Application No: 20/00307/DISC

Proposal: Discharge of Condition 12 (Construction Traffic Management Plan) of 19/00607/F

Location: Land At Skimmingdish Lane And Land And Roundabout At, Bicester Road, Launton

Transport Development Control

Figure 3: Route Restrictions Adjacent to Compound A1

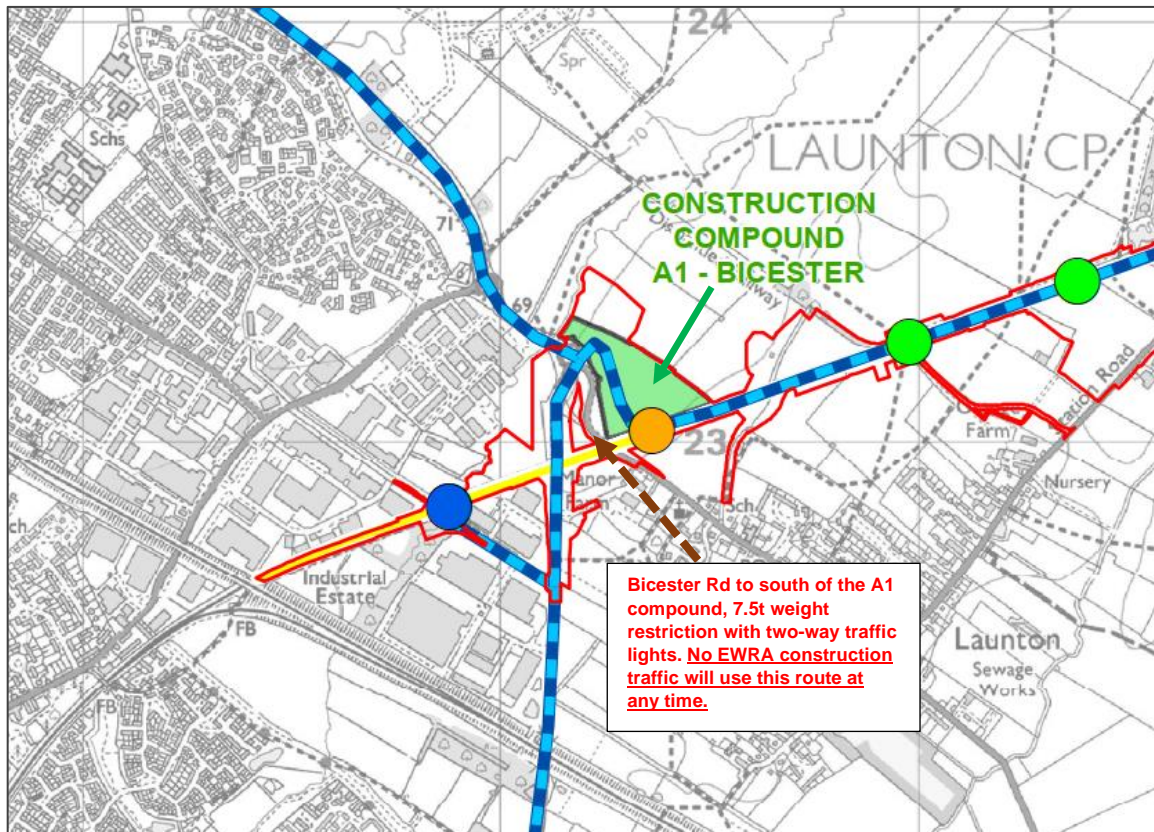
Figure 3, and para 6.1 Protection of highway assets: It is noted that Figure 3 shows an HGV route heading northwest along the A4421 from the Charbridge Lane roundabout. This does not correspond with the route to the compound described in 3.2, which is accepted. This point should be clarified, as the A4421 to the north must not be used to access this compound. Also, the construction route to compounds in Bucks off the A4421 is understood to be via Junction 10 and the B4100, so I am not clear what traffic would be using this section of the A4421.

This section of route gives us cause for concern because bridge assessment records for Launton Sluice (OCC ref. 0081), immediately NW of the roundabout, are poor, and there is a low risk that a weight restriction may need to be imposed.

Scale(s)	1:25,000	ELR & Project Chainage	N/A
Design Package Risk Classification	NORMAL	Sheet	1 of 12
Alternative Reference	Alternative_Ref	Revision	P01
Drawing Number	133735_RW-EWR-XX-XX-DR-LE-010690

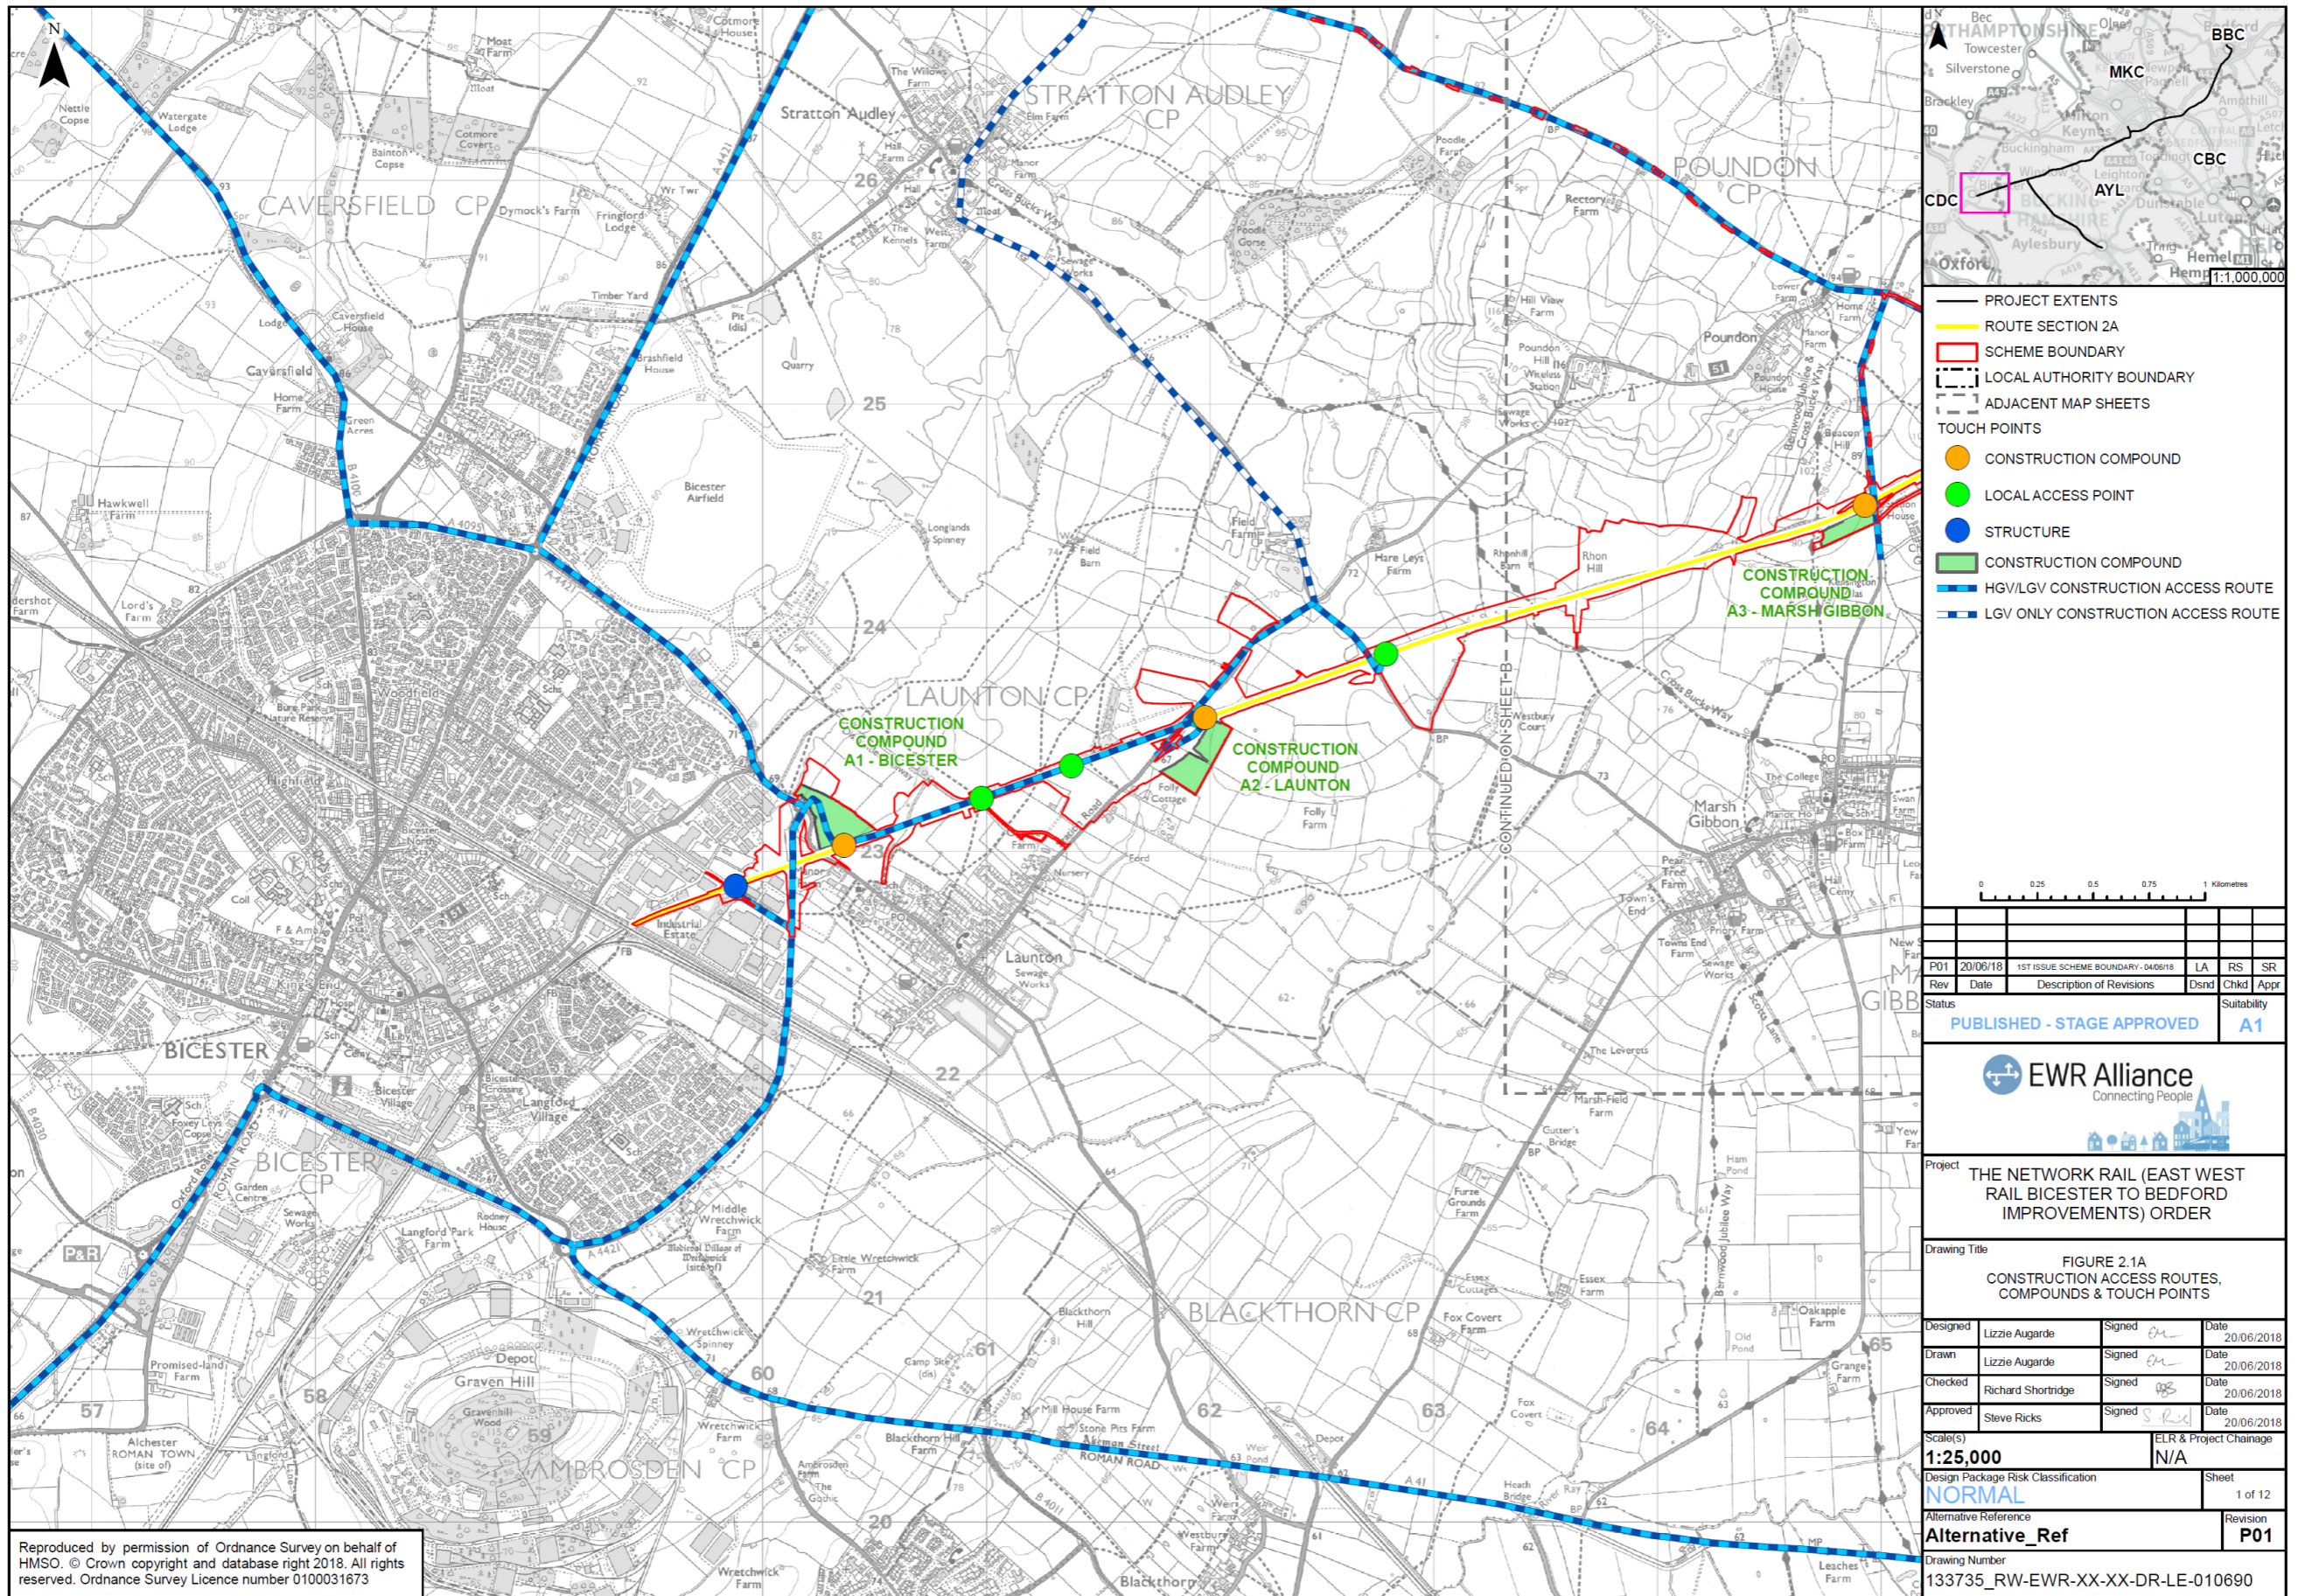
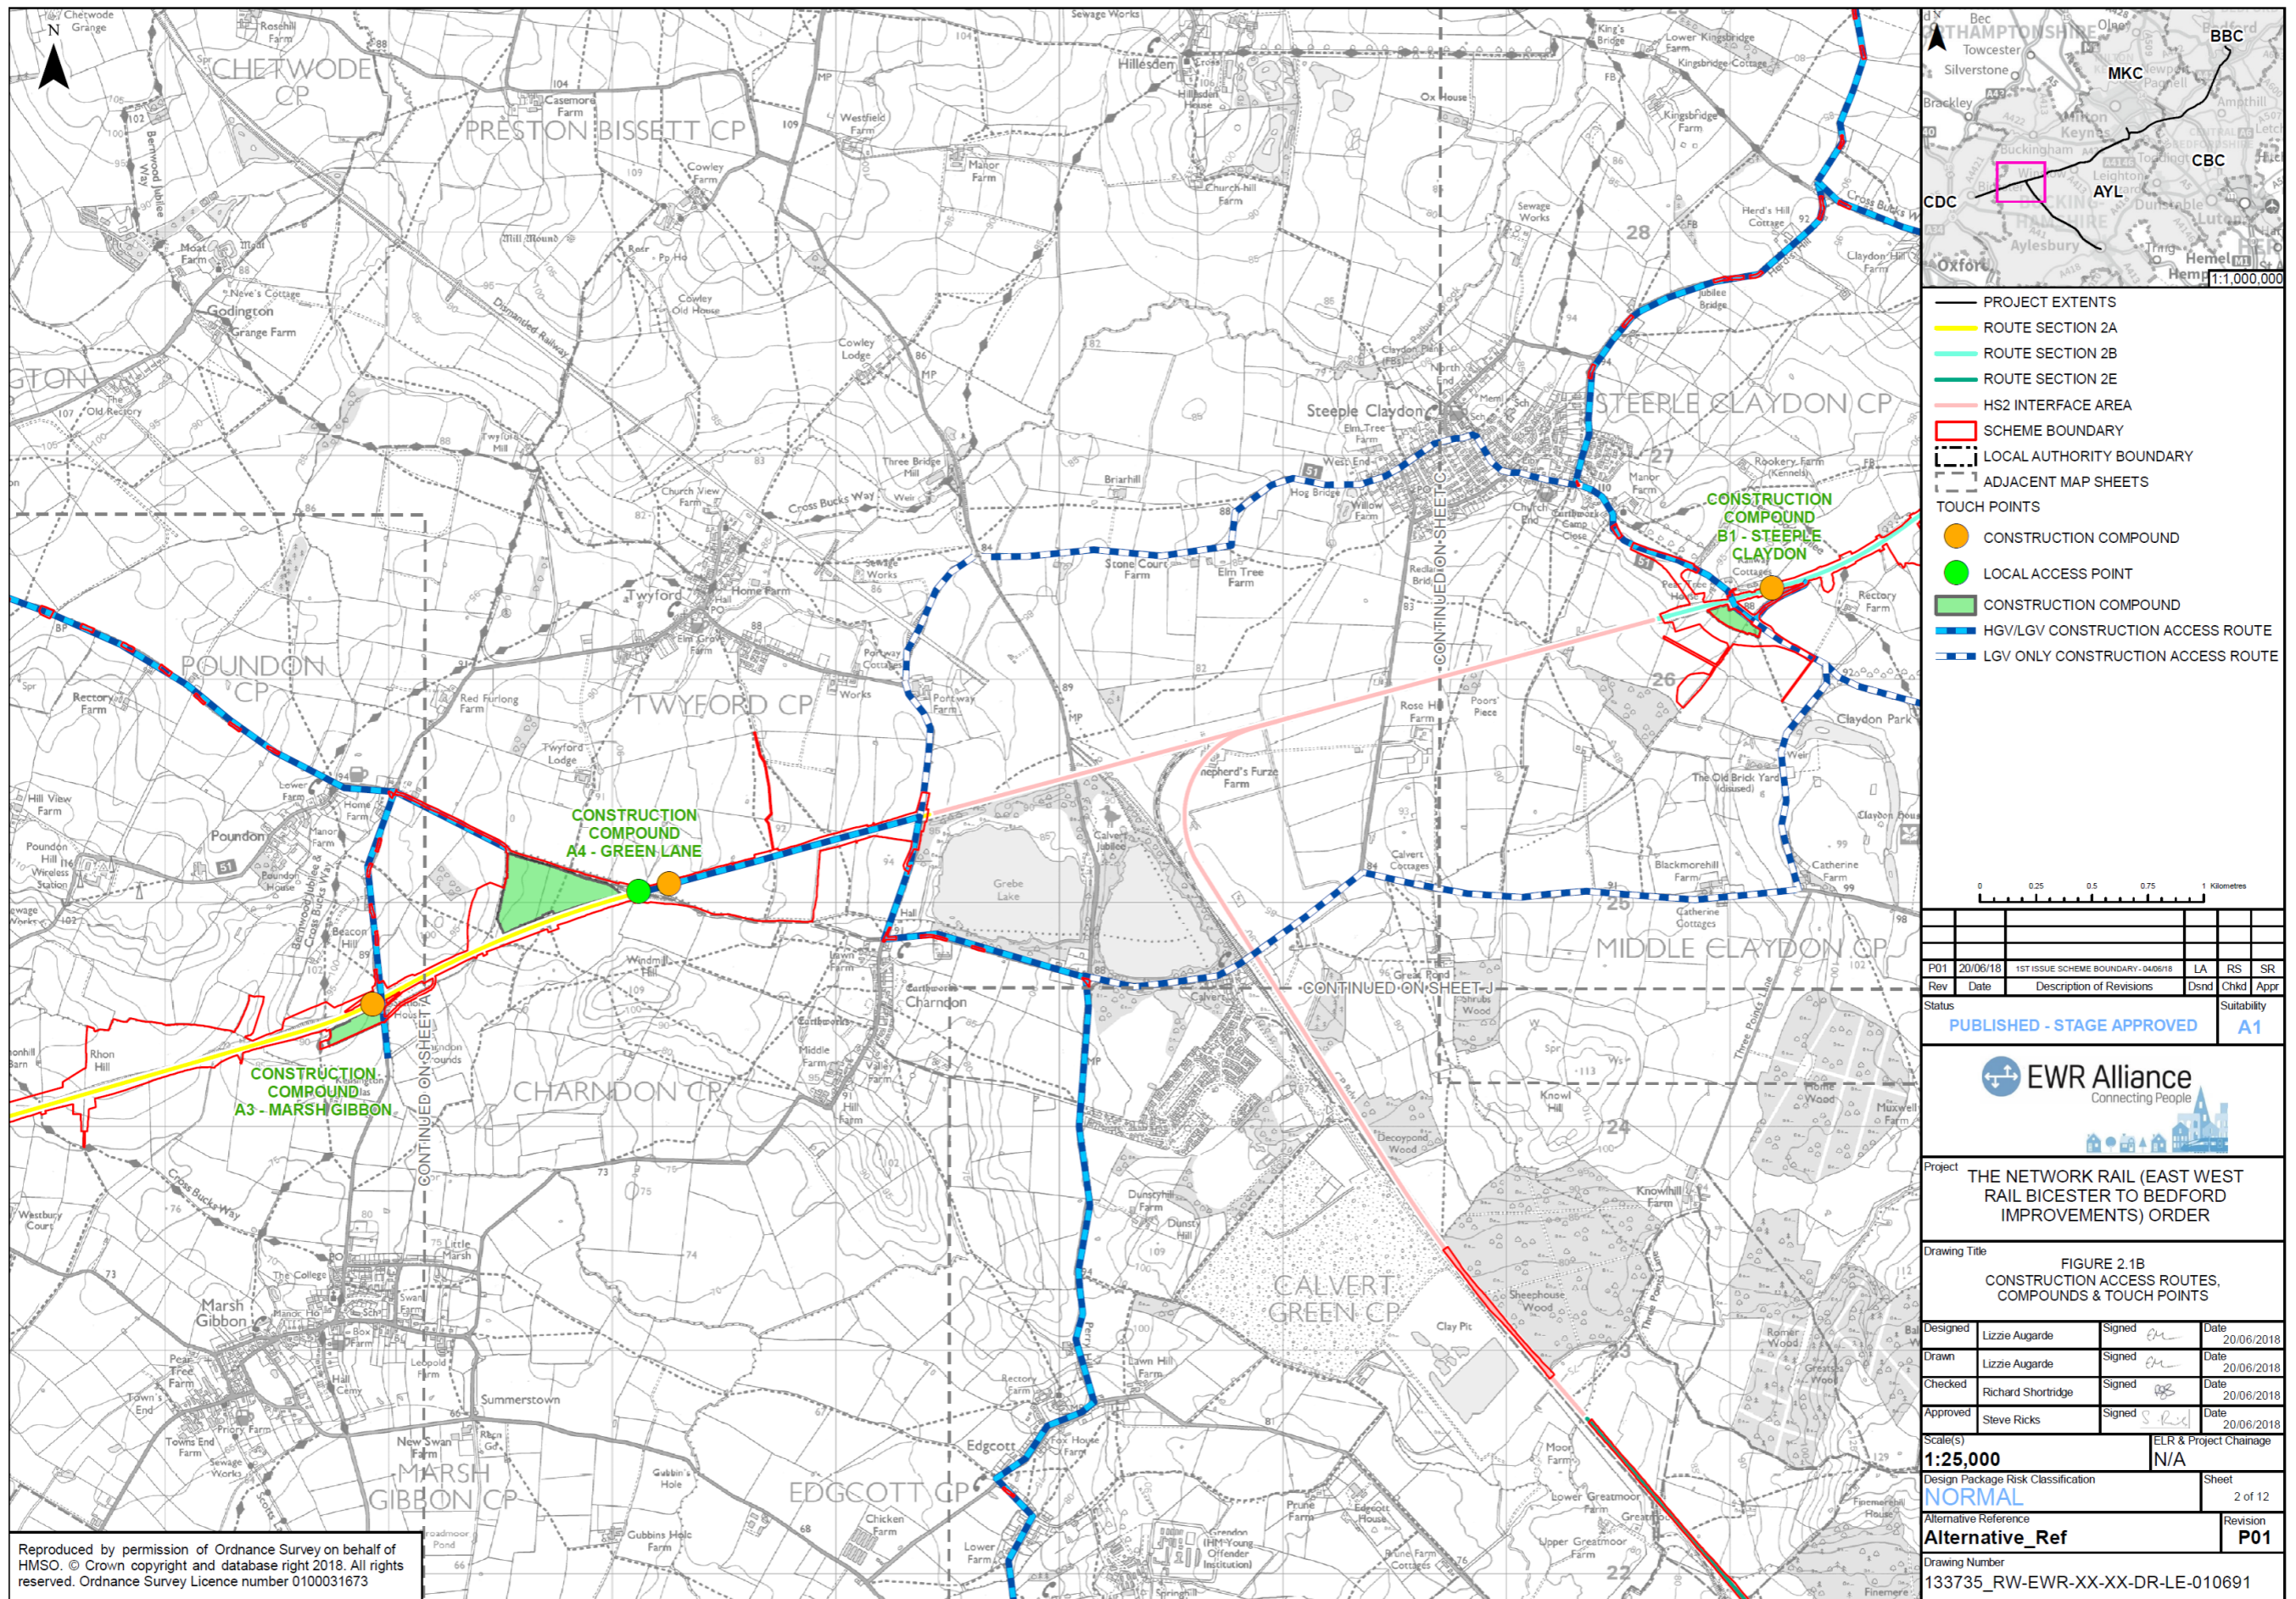
Appendix 1: We have significant concerns about the route proposed through Stratton Audley village for LGVs due to the environmental impact on this small village, which has properties very close to the road and no footways, lack of passing places along the route, and the constraints of the road layout. In relation to traffic associated with this compound, I note paragraph 3.2 which states 'There will be no construction traffic routed via Launton Village without prior agreement from the Local Authorities'. For the avoidance of doubt, OCC does not agree to any construction traffic, including LGVs, routing through Launton Village.
